Approval of reserved matters following outline consent WA/26/18/OUT for layout & scale for 6 No. dwellings & 6 No. detached garages.

Lanes End West Walberton Lane Walberton

Thank you for your internet representation made on 9th March 2019 which has been recorded as '**an objection**' with the comments as follows:

PLOTS 1 AND 2 FLOOR PLANS AND ELEVATIONS

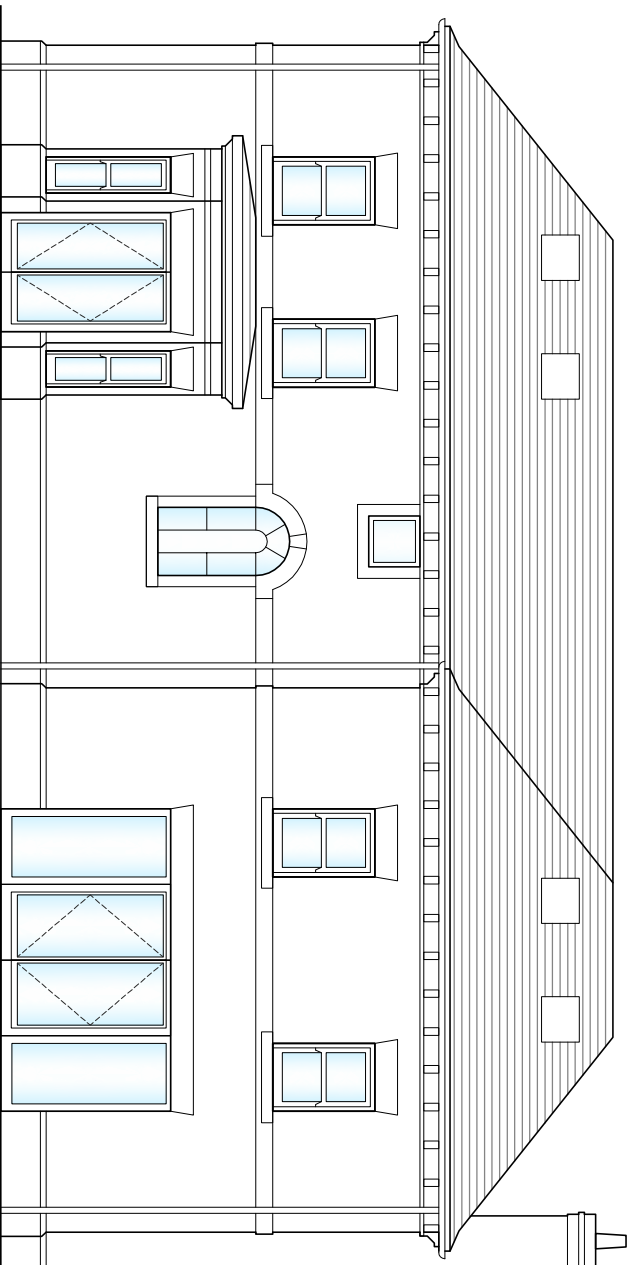
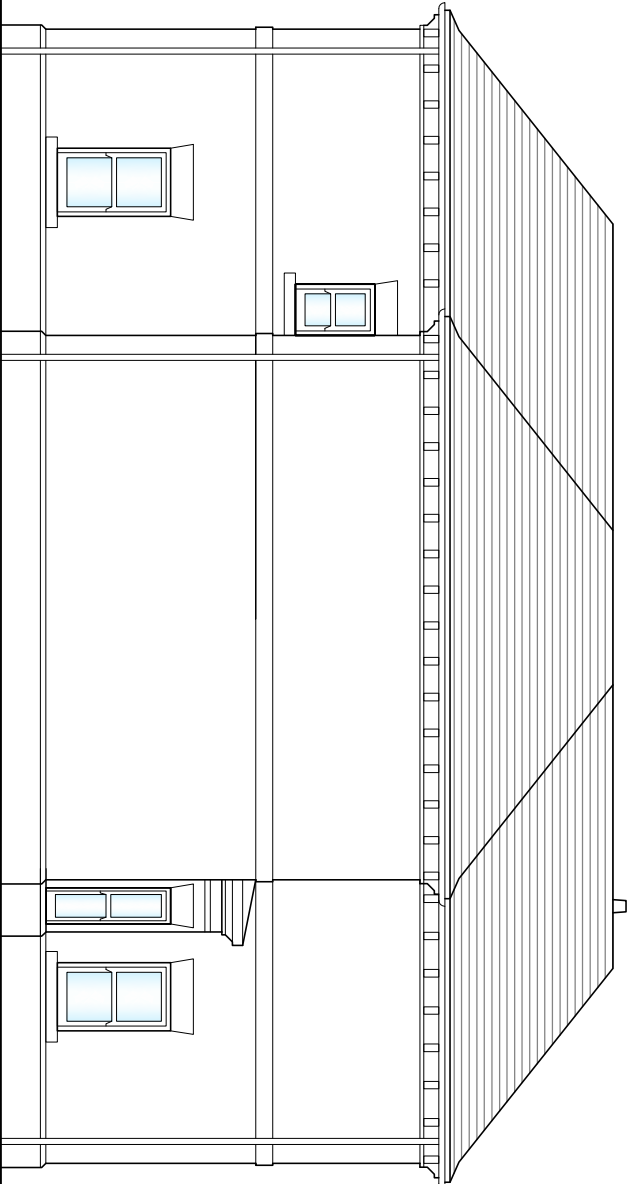
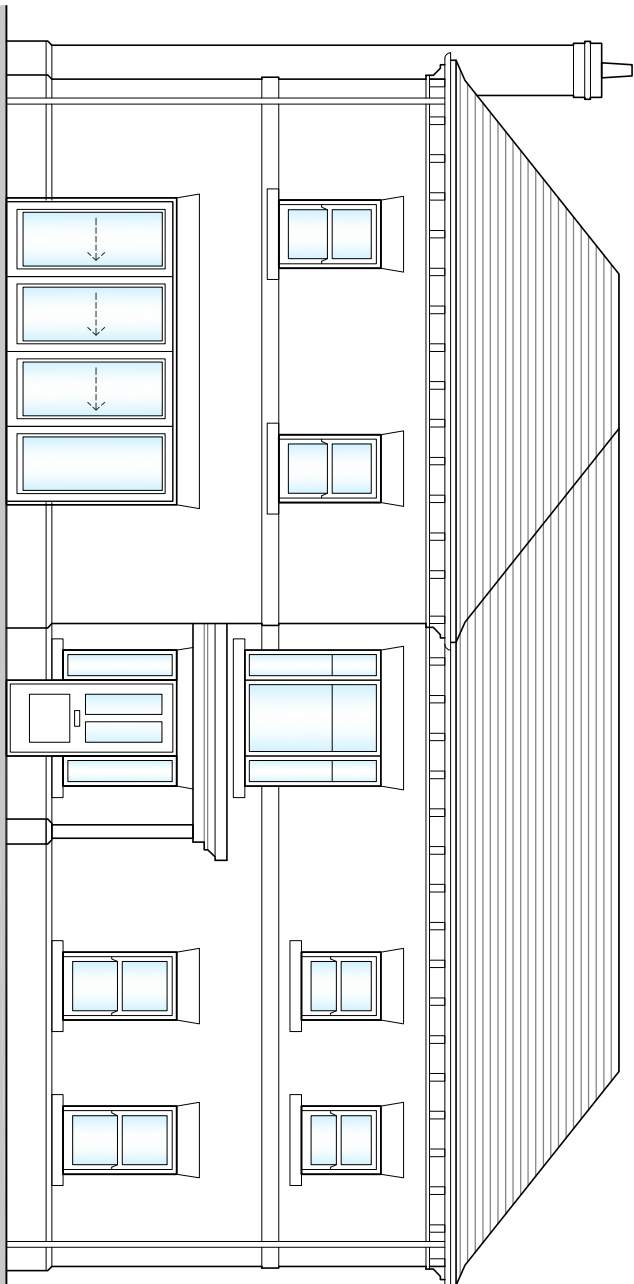
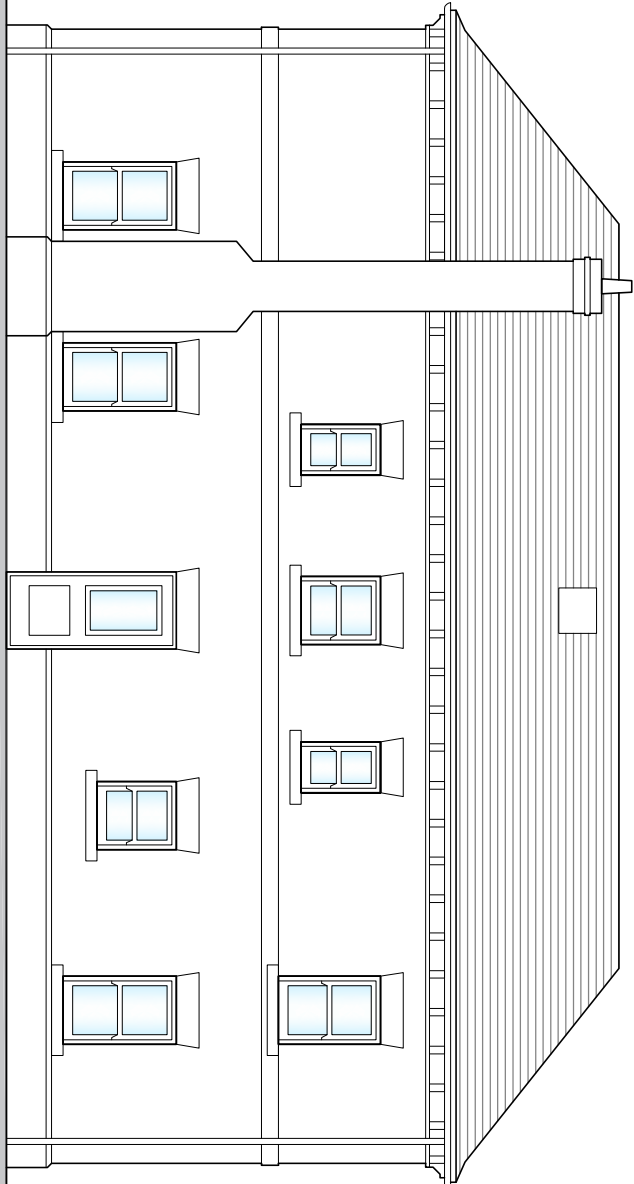
The houses on the west side of the plot (houses 1 and 3) will have a very domineering effect over White Cottage which is a bungalow. The height of these properties should be restricted.

There should be no windows in the roofs on the west side of house 1 and the north side of house 3 otherwise these will invade the privacy of White Cottage.

There should be no windows on the west side of house 1, garage 1 and garage 3. Including the roofs of these buildings.
